Recommendation Report for Planning Permission for Works or Extension to a Dwelling

REF NO: BR/35/22/HH

LOCATION: 20 Pevensey Road
Bognor Regis
PO21 5NS

PROPOSAL: Single storey side/rear extension for use as a annexe.

Proposed Rear Annex Plans and Elevations Planning
Date February 2022
Scale 1:50

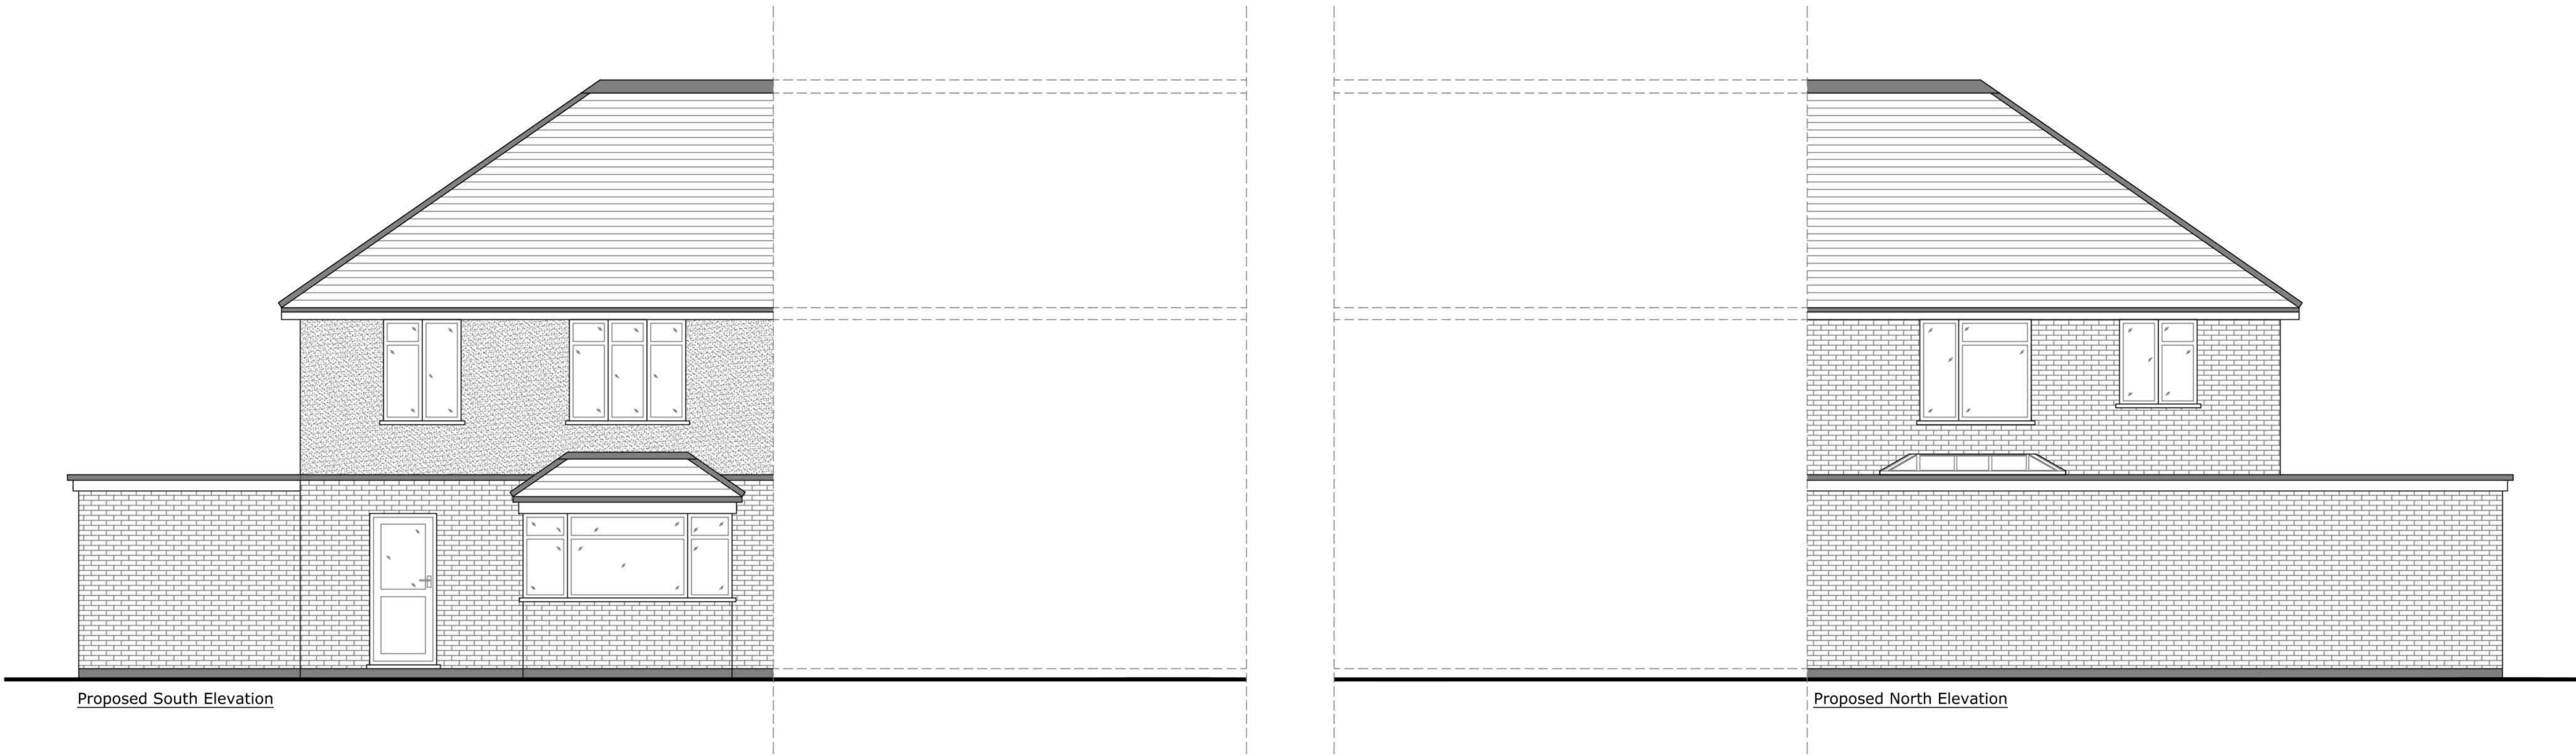
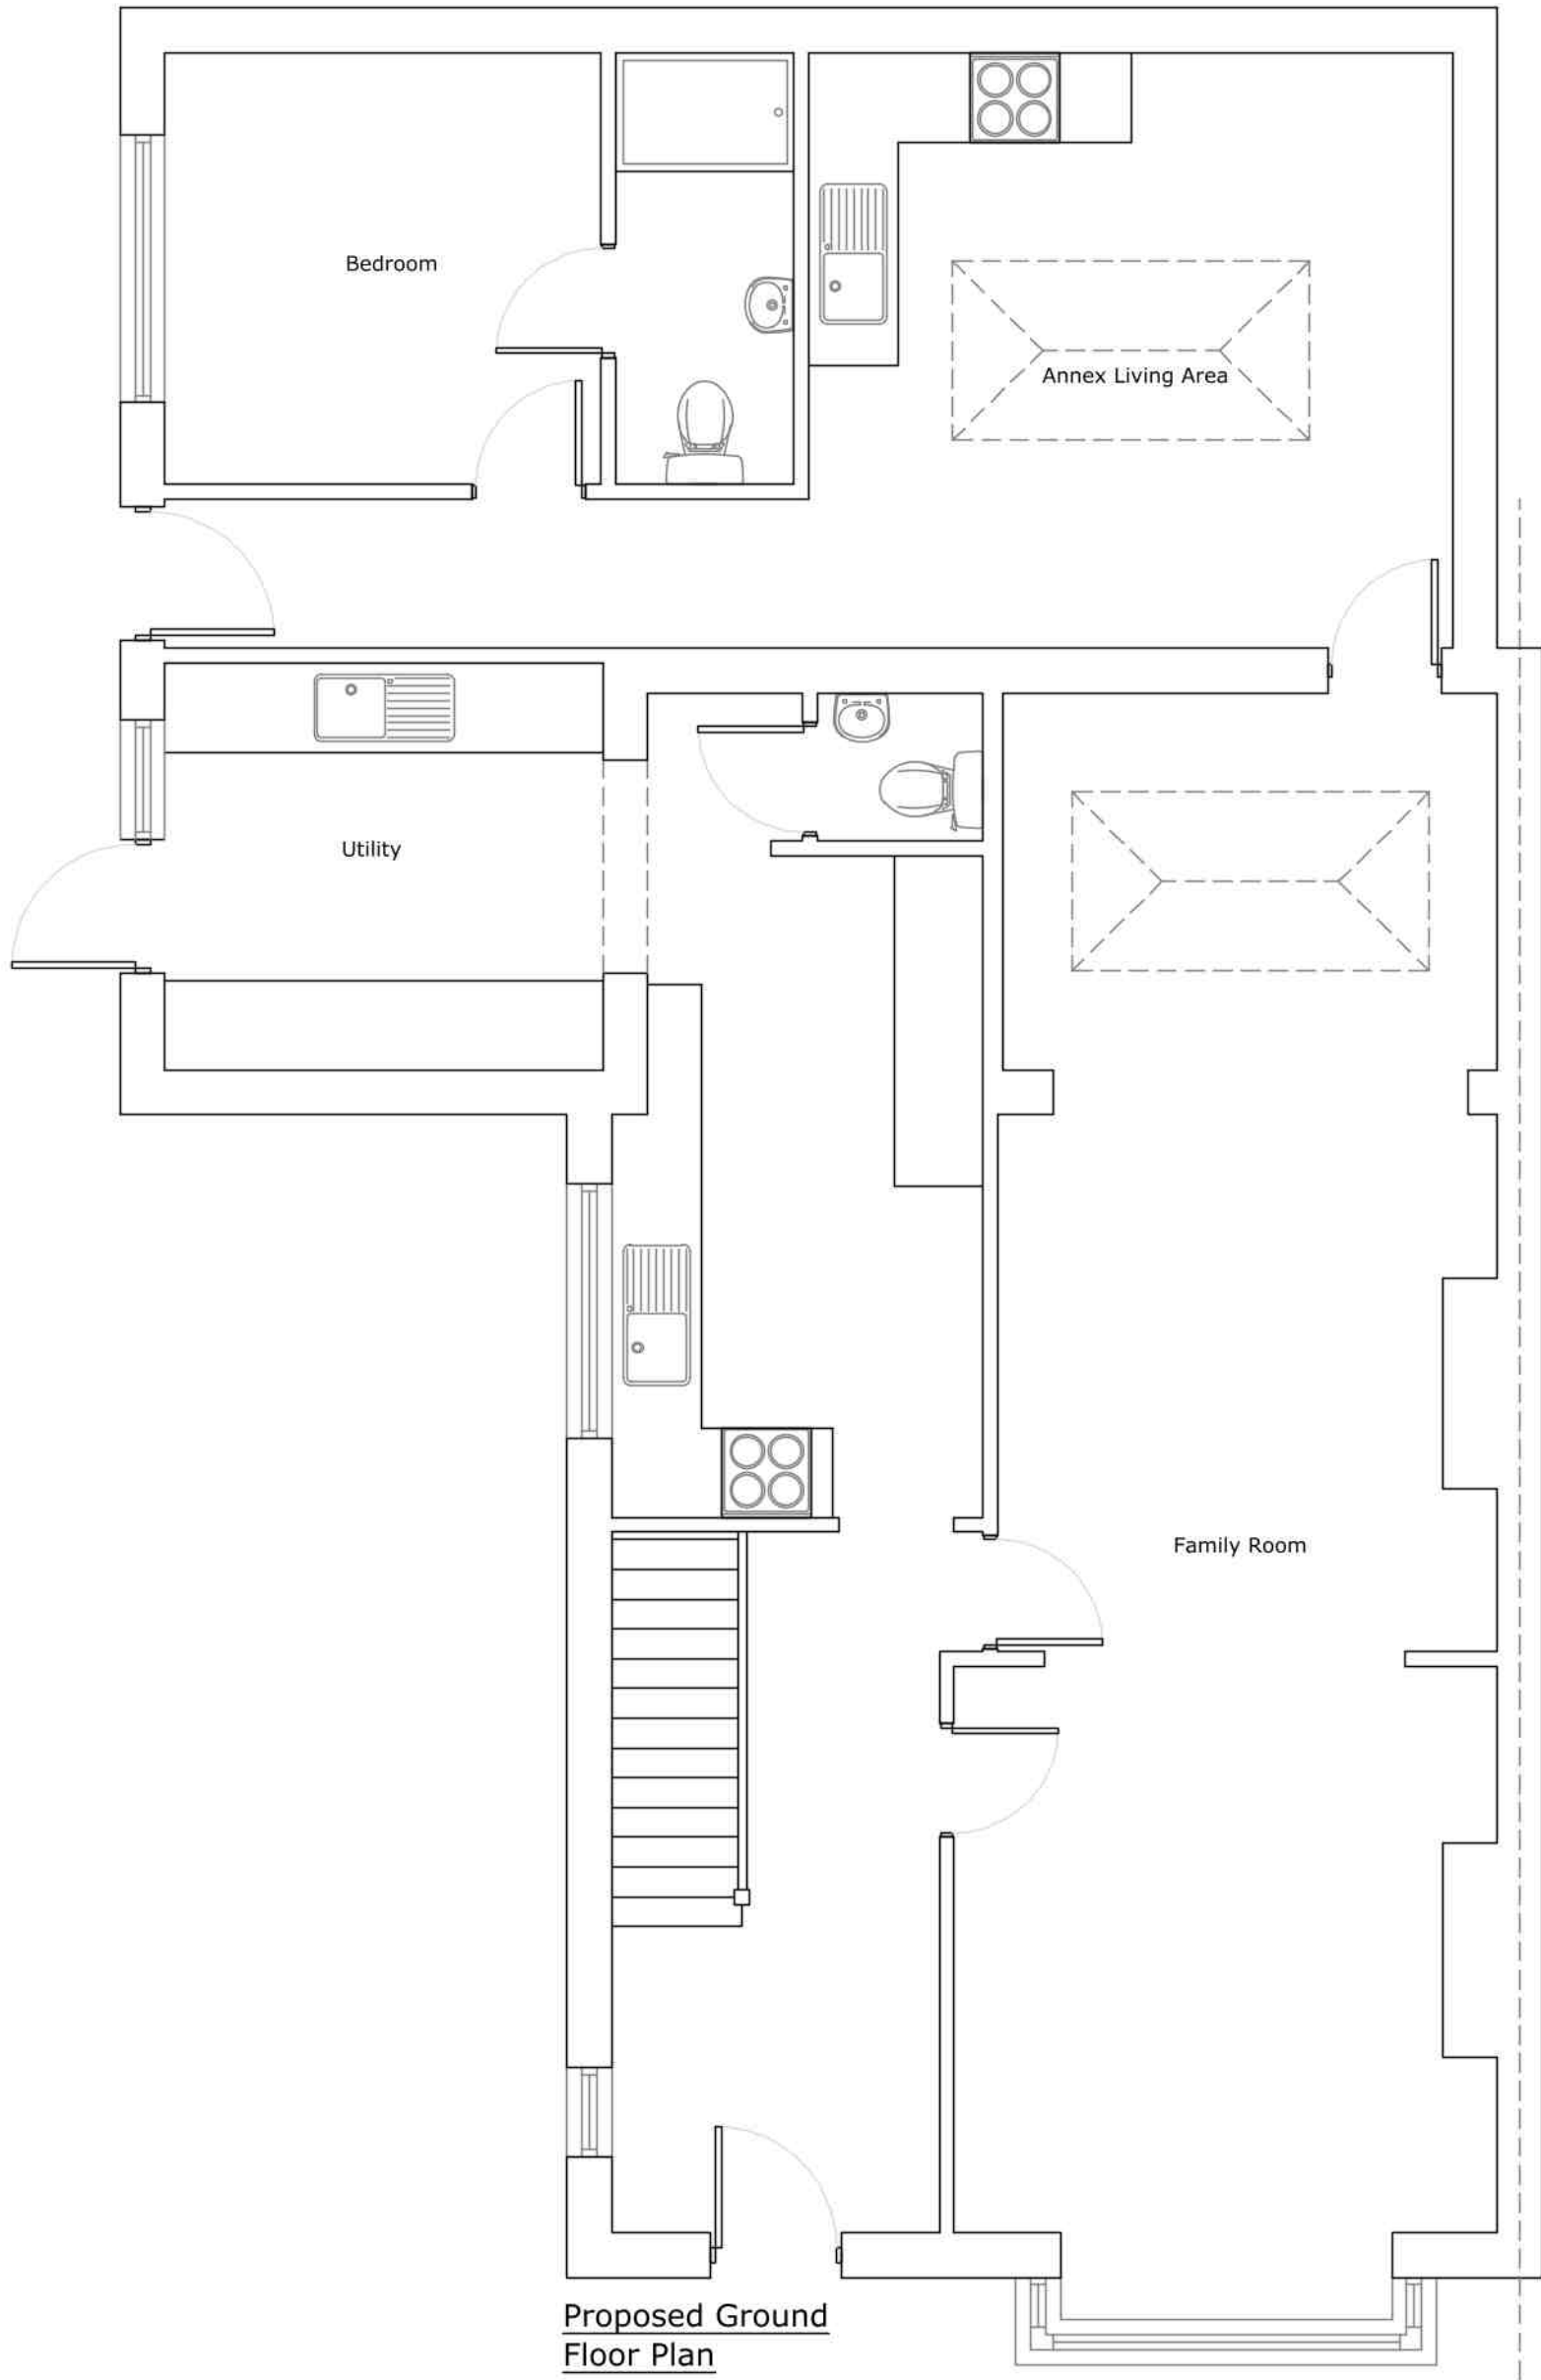
The development will run along the full rear and wrap around the side of the property retaining approximately 8.2m to the principle elevation. Around 5.2m is retained to the western side boundary which consist of fencing and hedging.

The proposal does add bulk to the rear of the property although being single storey and with sufficient garden space retained, the scale is considered acceptable. It will have a flat roof and appears subservient to the host dwelling.

The extension will essentially wrap around the dwelling from the side and extend along the full rear, with a depth of around 4.2m. This does extend some distance along the boundary to the south east and therefore will give rise to slight overbearing at No.18. The proposal will intersect a 45 degree angle when drawn from the centre of the closest window to the boundary. This is not significant in which a refusal is justified. An extension could be constructed up to this depth with prior approval with no objections from the neighbours and with no representation received, the development is considered acceptable. The existing outbuilding if located closer to the boundary would have a similar impact.

The structure will have a height of 2.8m and retain around 1m to the rear boundary. This is slightly reduced in height than the existing outbuilding.

To the rear, there are two ground floor windows to the side of No.2 although sufficient separation to the boundary and with the a modest height, the proposal will not result in harm additional that that which is already achieved from the existing outbuilding.

Proposed Rear Annex Plans and Elevations Planning
Date February 2022
Scale 1:200 1:1250

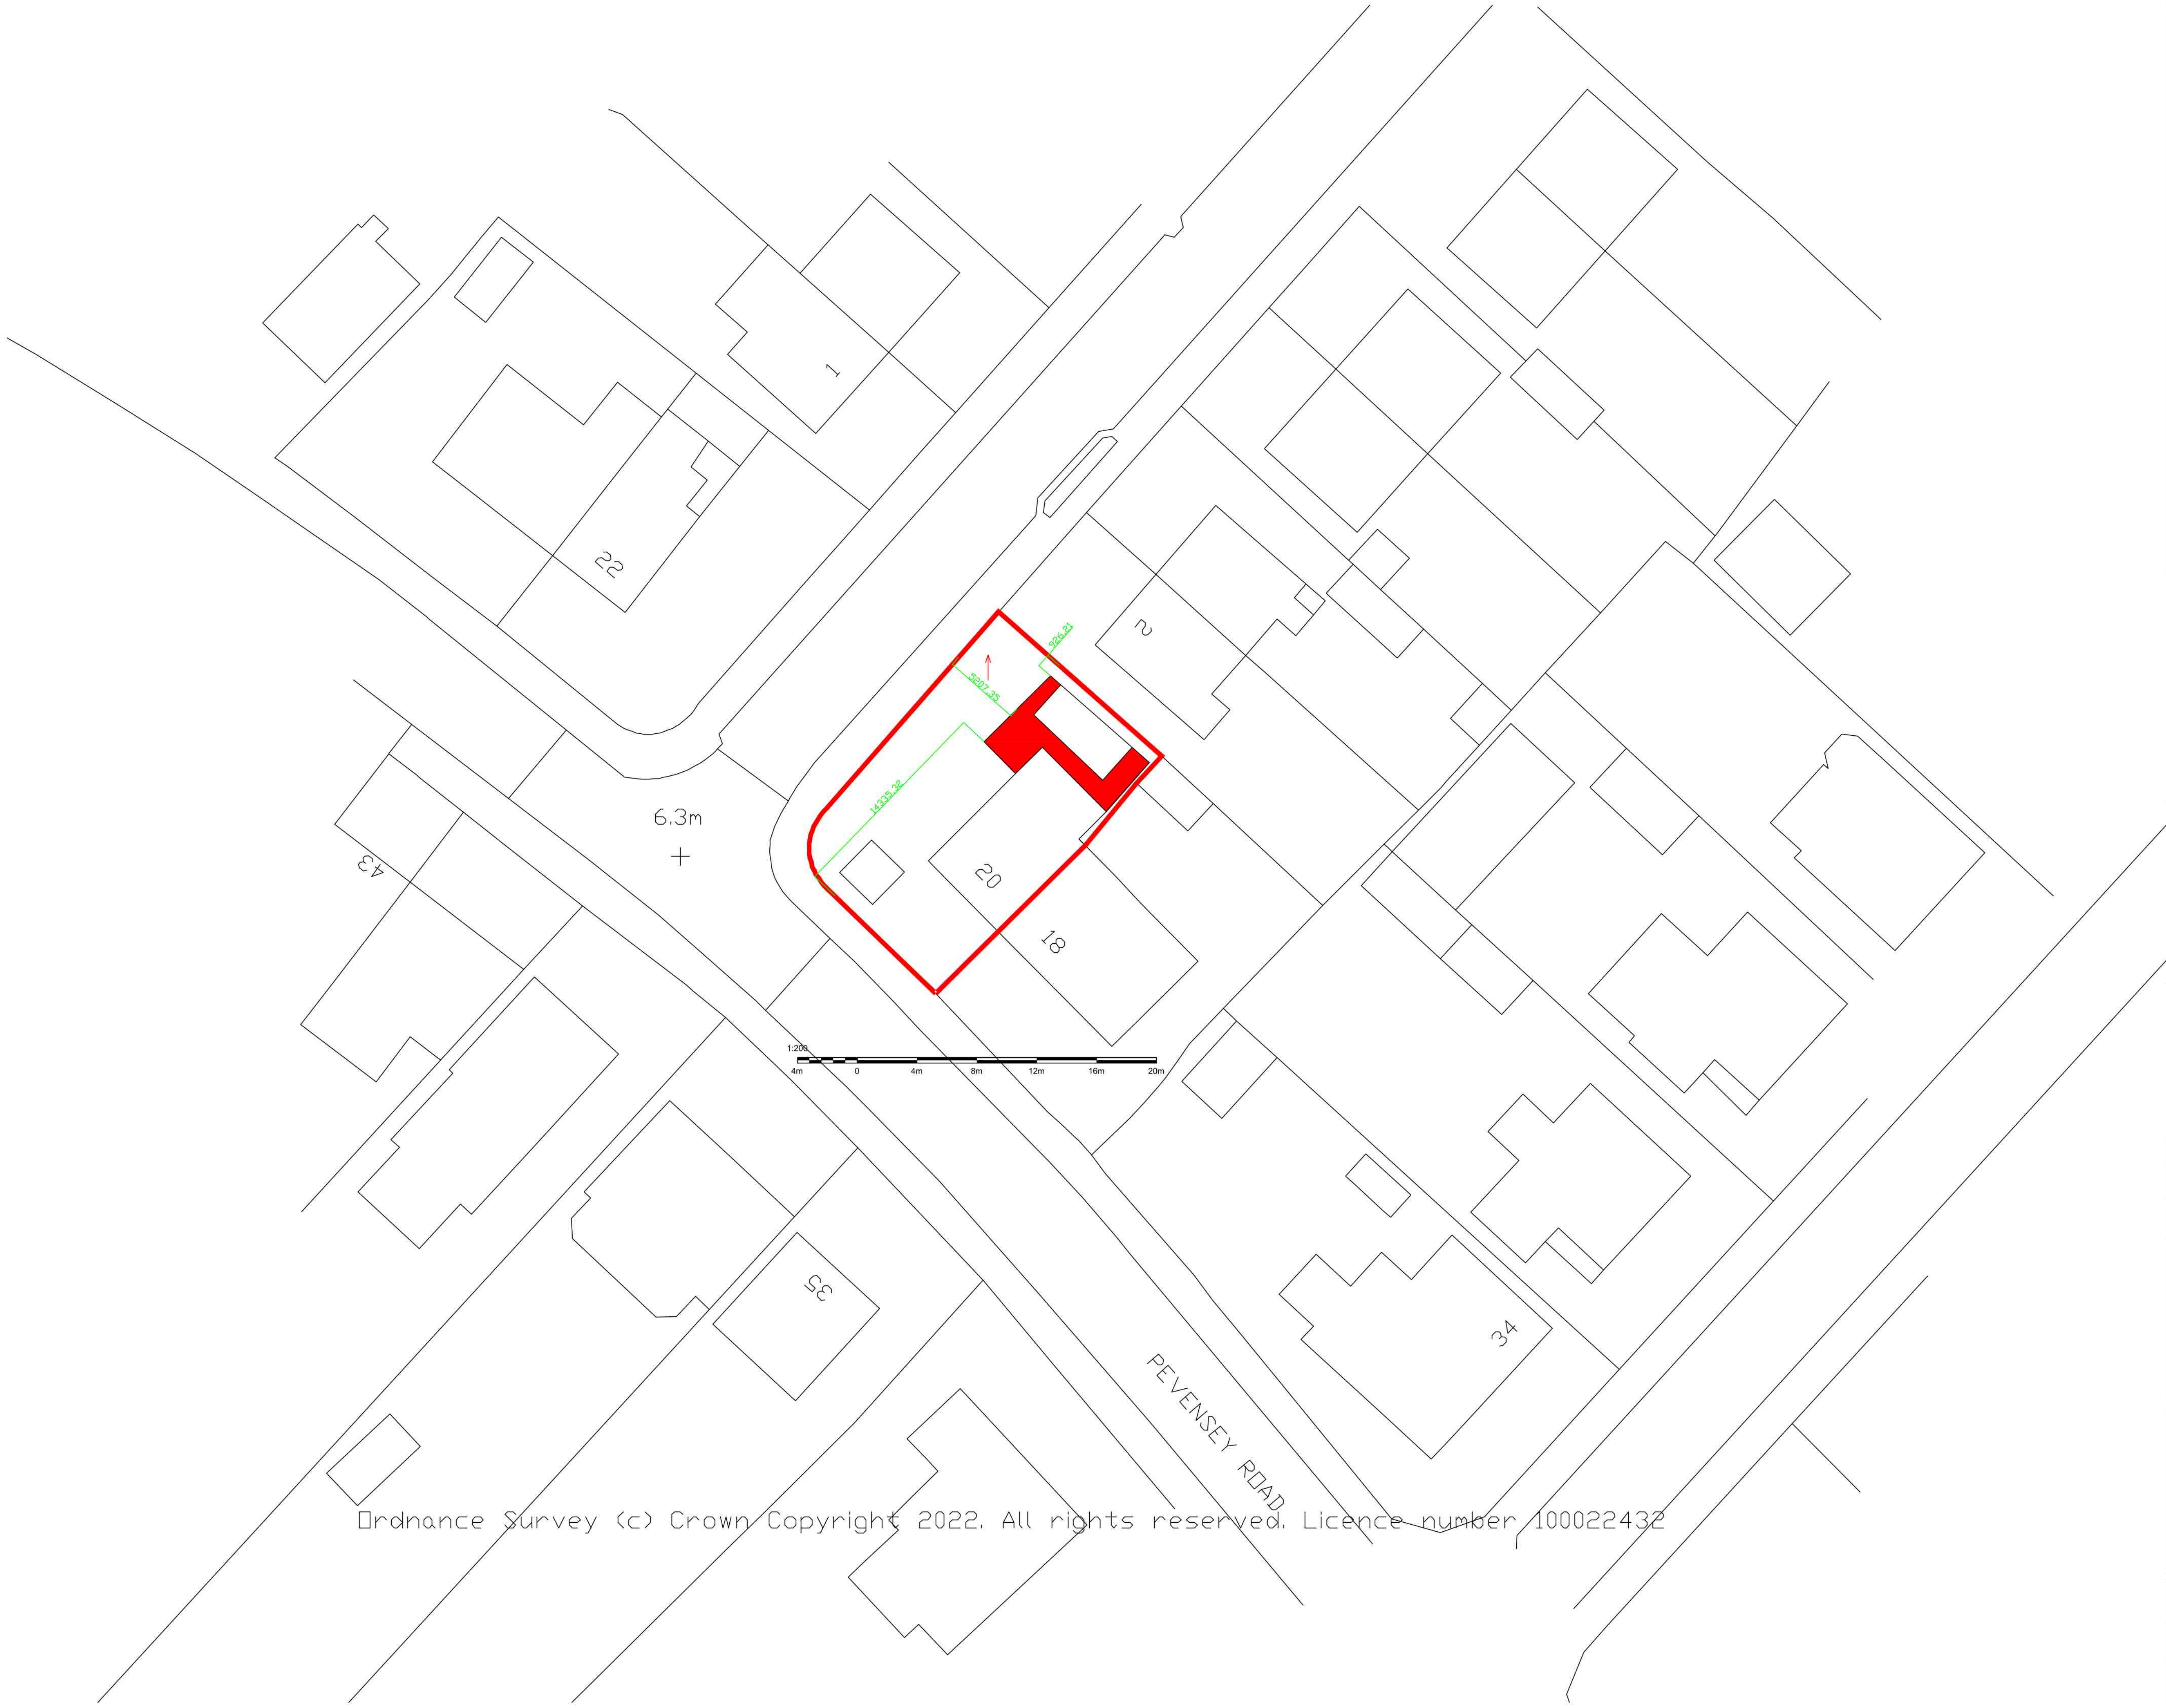
The extension is to the rear and will be partially visible from the side elevation due to the siting of the property which is located to a corner with Frith Road to the north side and Pevensy Road to the front.
